Rezoning Transportation Analysis

Petition Number: 2020-168

General Location Identifier: Tax ID 10110157

| Date | Description |
|----------|--------------------|
| 12-28-20 | First Review (WB) |

SHEET NO:
RZ-1

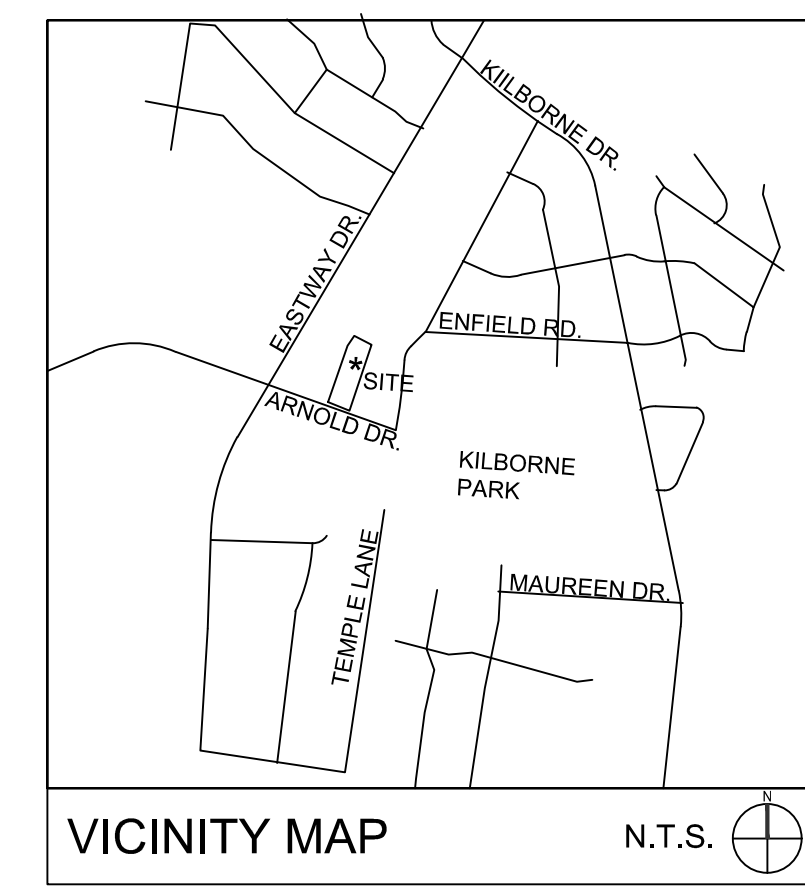
1. **Curbline:** The proposed zoning district has a setback measured from back of the existing or proposed future curbline.
 - a. **Arnold Drive:** The curb and gutter needs to be installed at 17.5 feet from the road centerline.

Label and dimension the curb and gutter from the centerline for each road to the back of curb on the site plan.

3. Revise site plan and conditional note(s) to commit to dedicating 25.5 feet of right-of-way, to be measured from the road centerline. Label and dimension the right-of-way from the road centerline.

4. A site plan note(s) specifying dedication and fee simple conveyance of all rights-of-way to the City before the site's first building certificate of occupancy is issued is needed. CDOT requests rights-of-way set at 2' behind back of sidewalk where feasible.
5. A site plan note specifying that all transportation improvements will be approved and constructed before the site's first building certificate of occupancy is issued is needed. The petitioner may phase transportation improvements if said improvements and phasing are explicitly described in site plan notes.
